#### COMMUNITY DEVELOPMENT DEPARTMENT

June 28, 2022

Re: PA22-019 - Groundhog PRD - Technical Review 1

DRAWING:	C - 4
SHEET:	4 OF 7

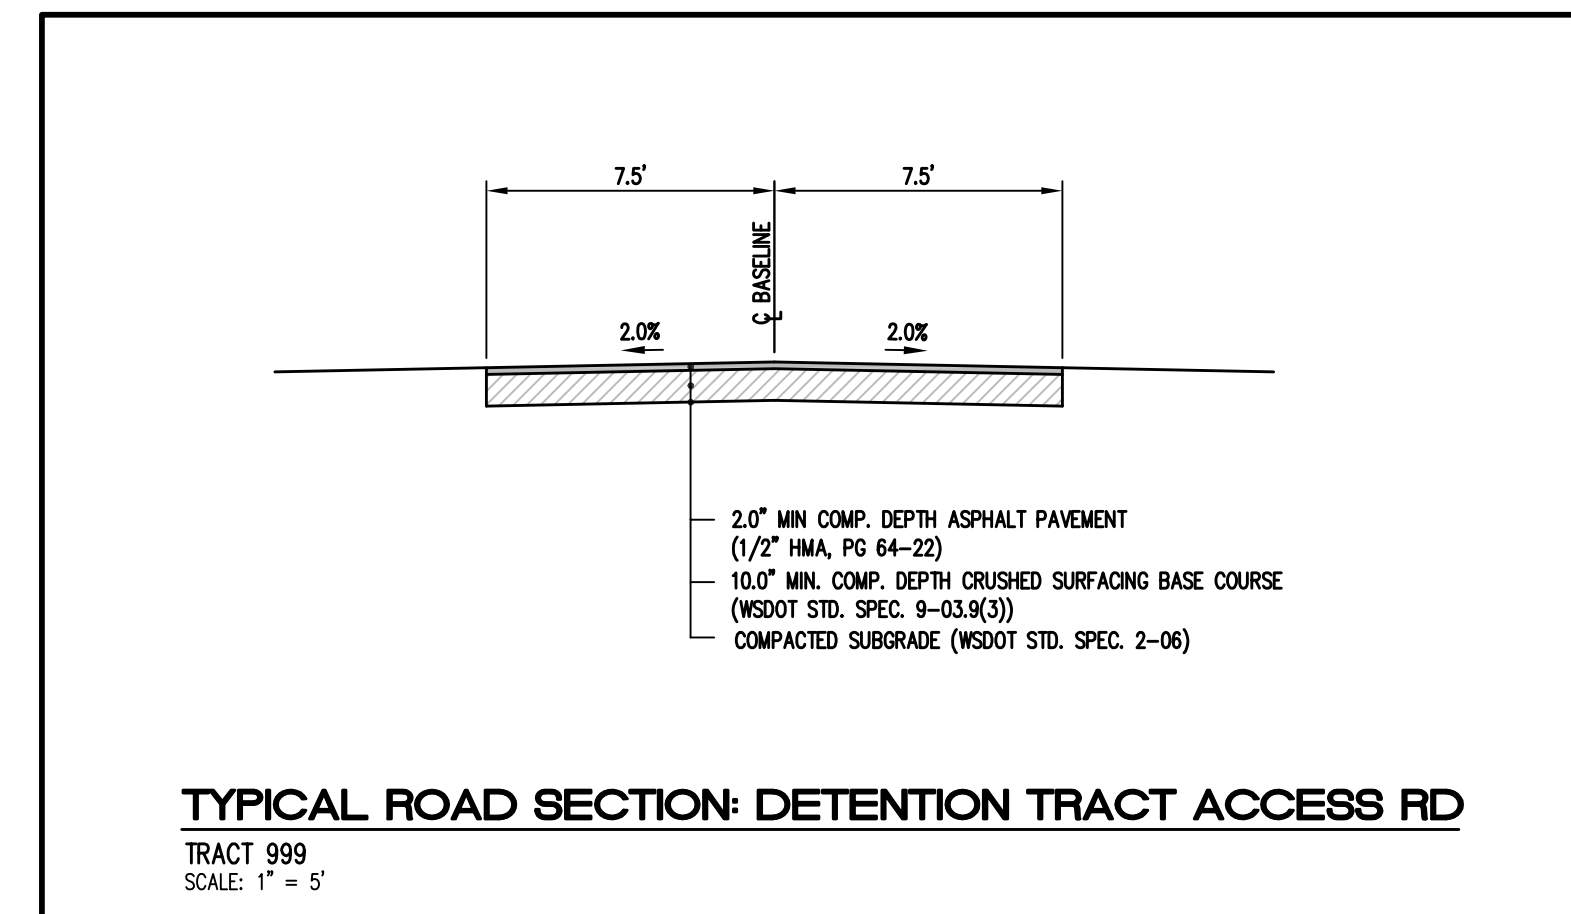
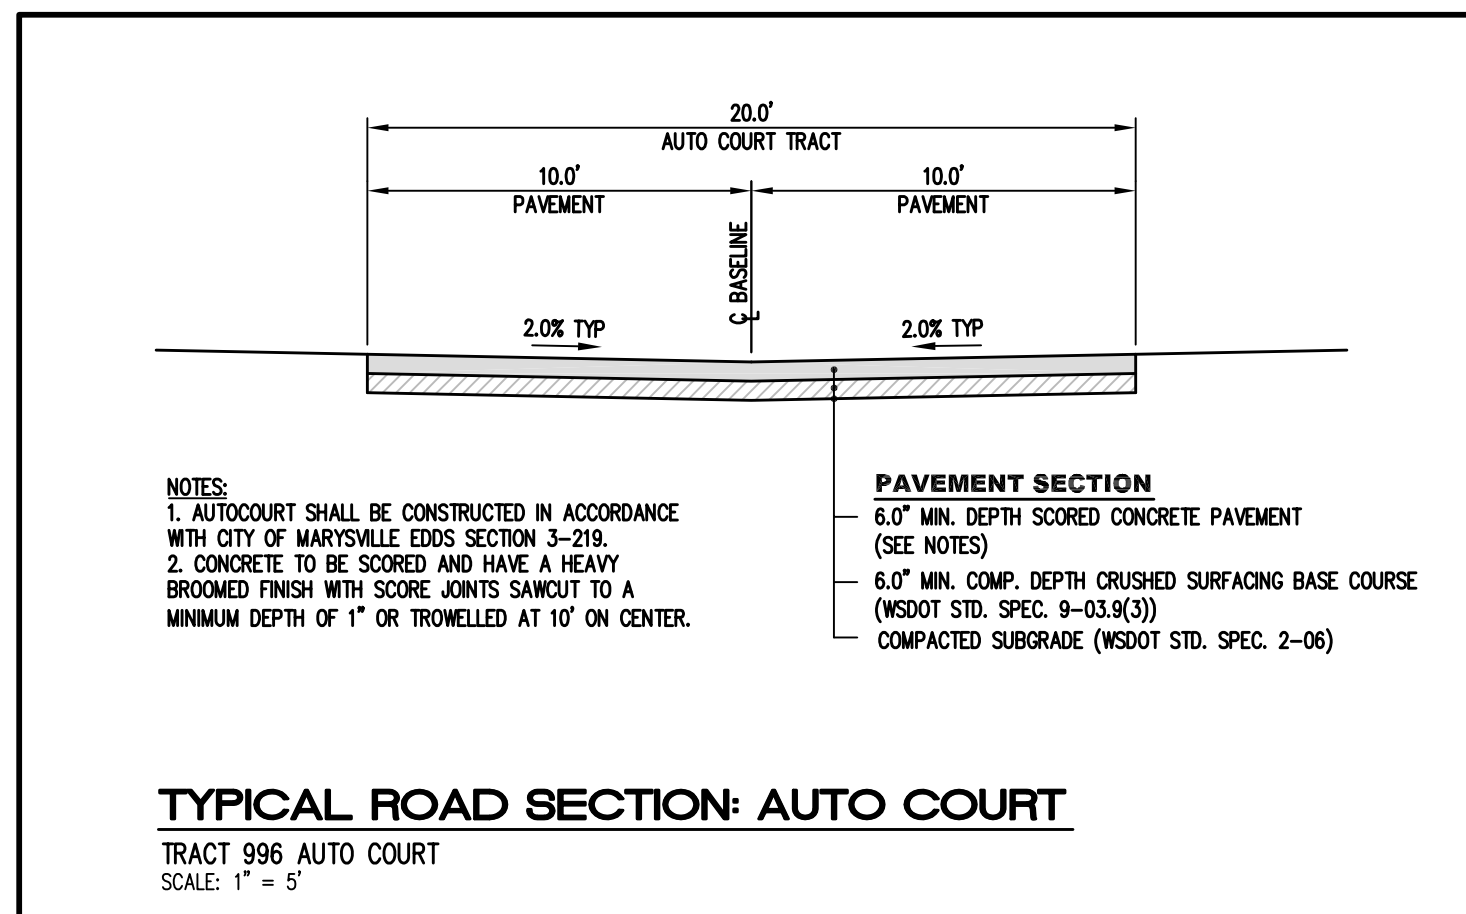
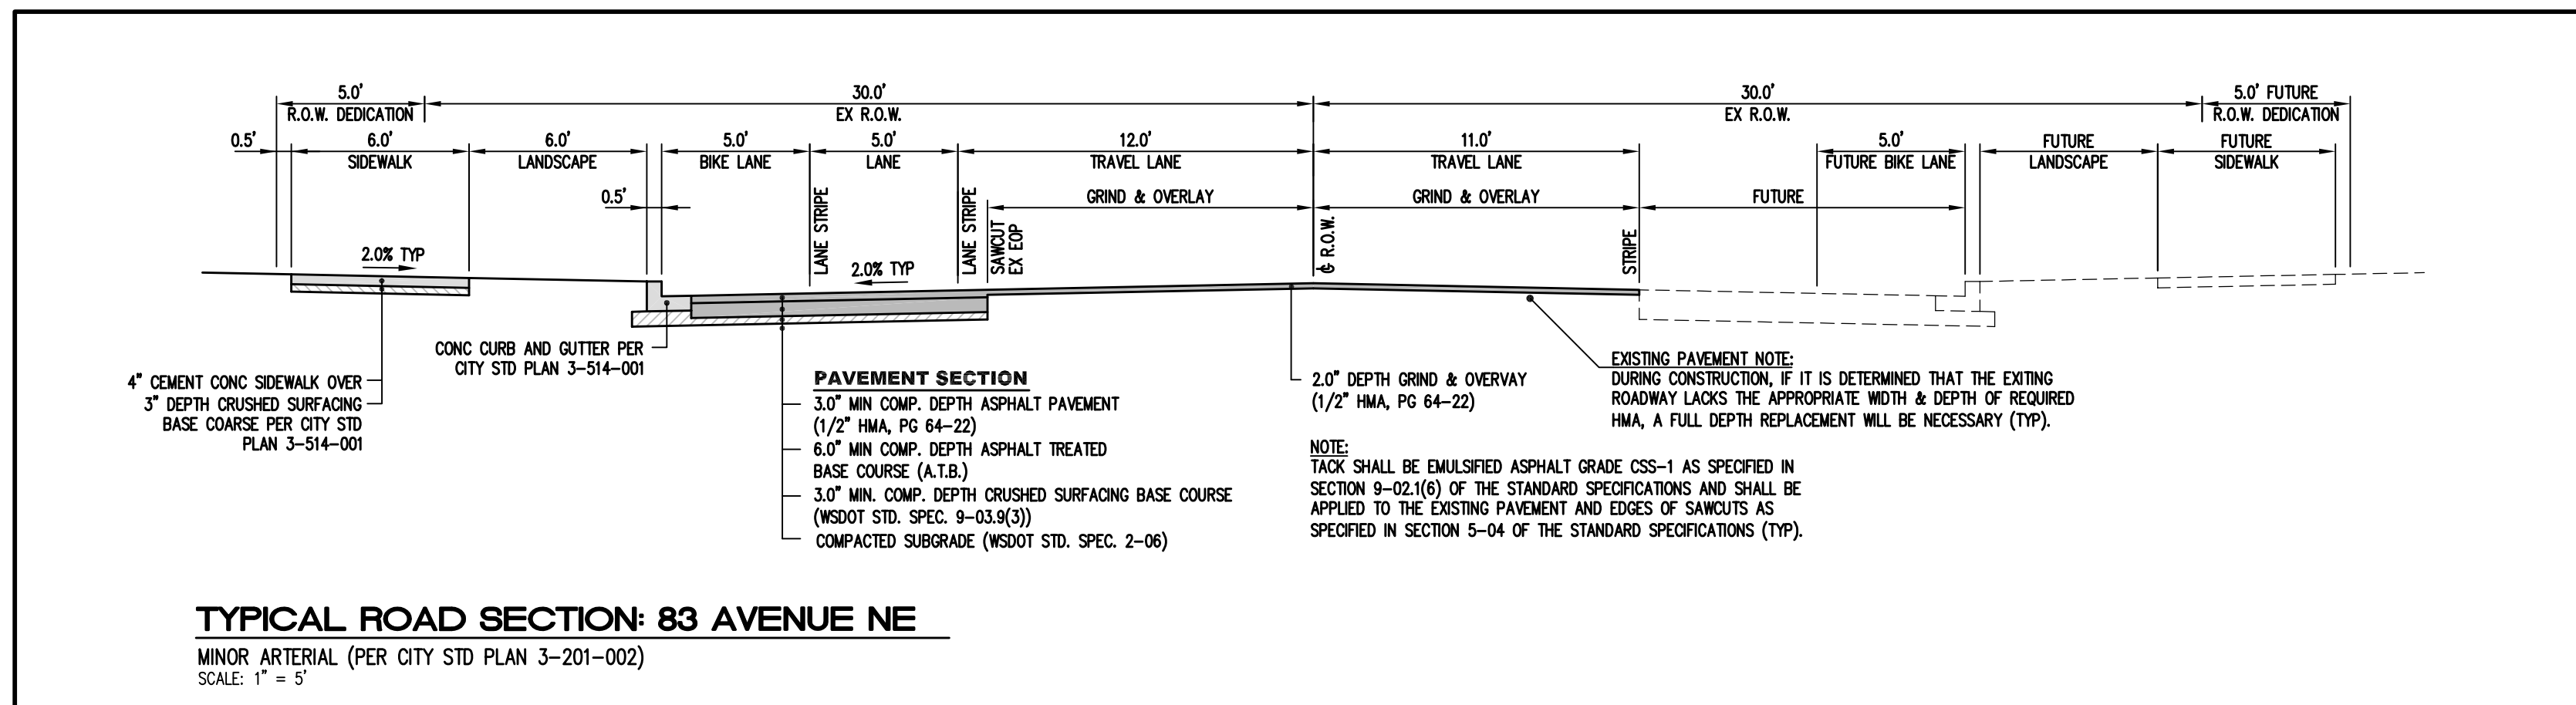
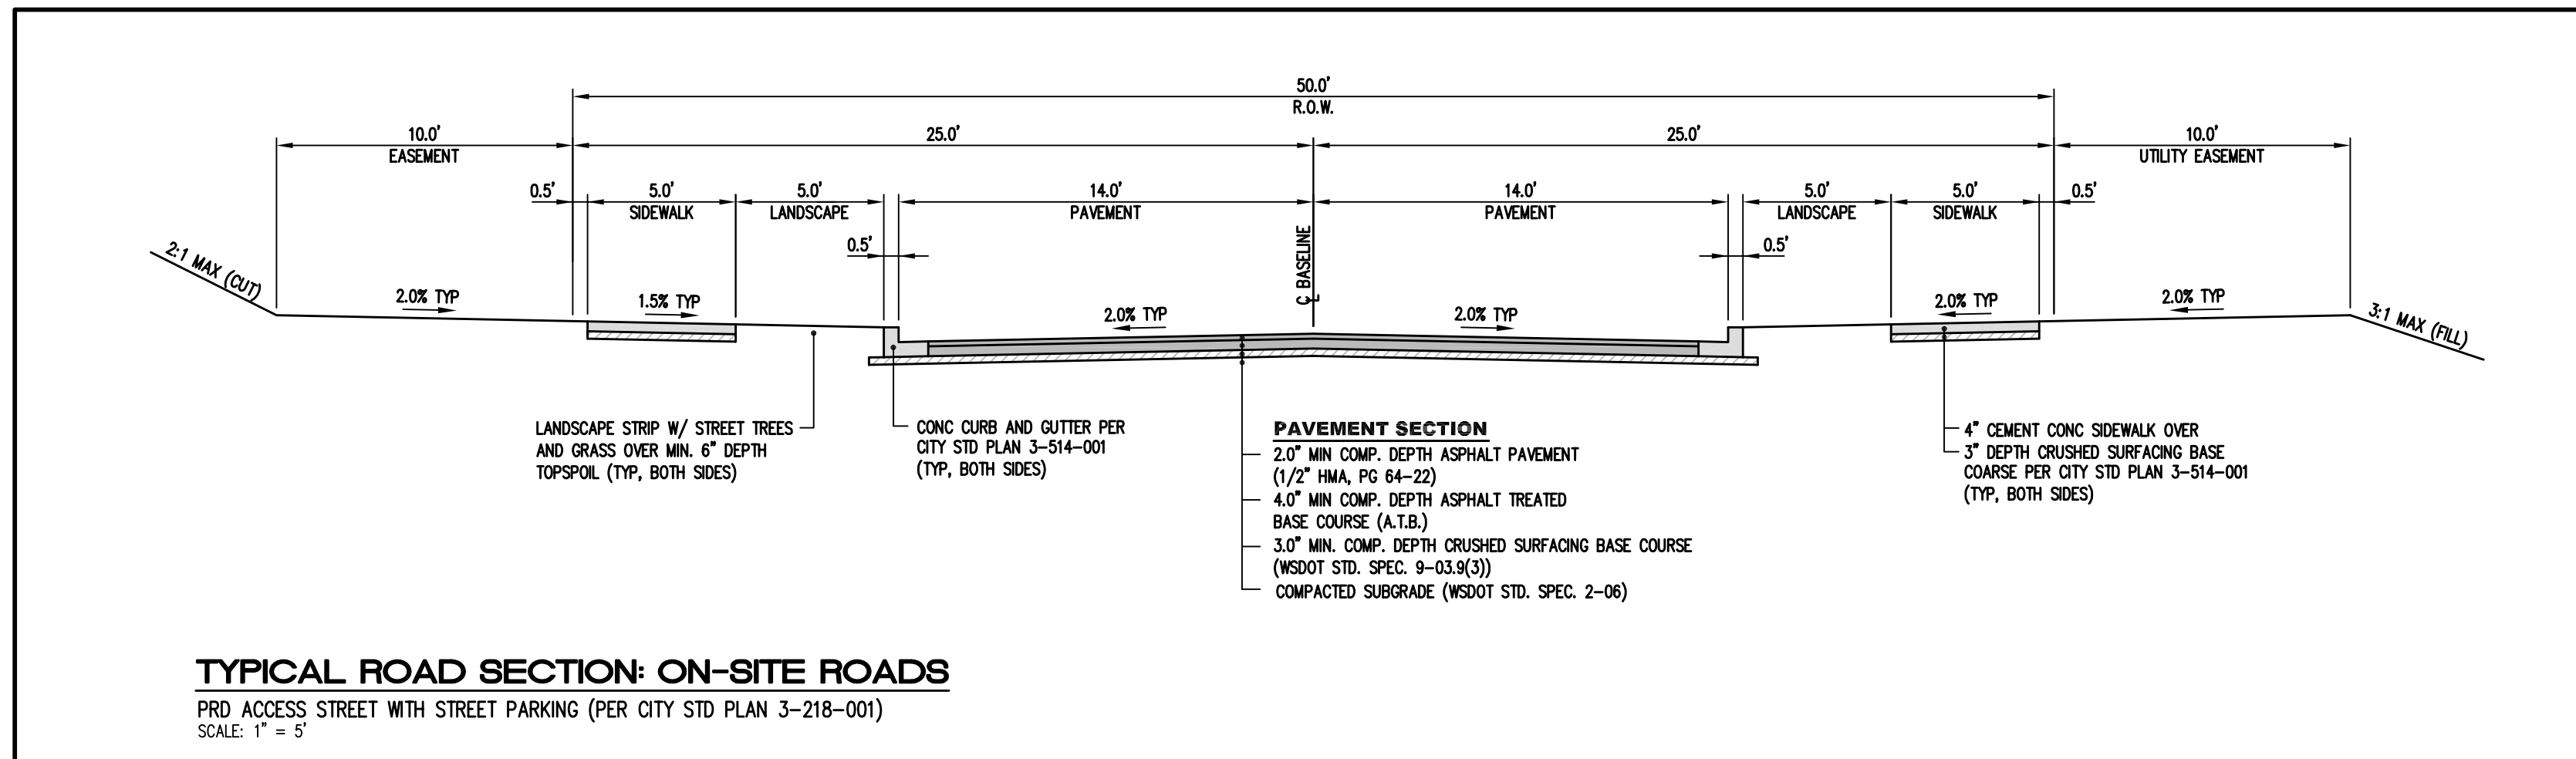
- 1. Include File Number PA22-019 on all future correspondence, in addition to all site, civil and landscape plans.
- 2. Based on review of **Sheet C-4**, there appear to be multiple retaining walls proposed with development. Please clarify how compliance with MMC <u>22D.050.030(4)</u> is to be satisfied if the proposed retaining walls exceed 4 ft. in height.
  - 2.1. Amend civil plans to add the top and the base elevations for all retaining walls as well as off-site topography to determine any impacts to adjacent properties due the wall massing.
  - 2.2. If the walls are to be terraced, the terraced sections are required to be separated by a 2 ft. landscaping bed. If terracing is required, add the 2 ft. landscaping bed to the landscaping plans.
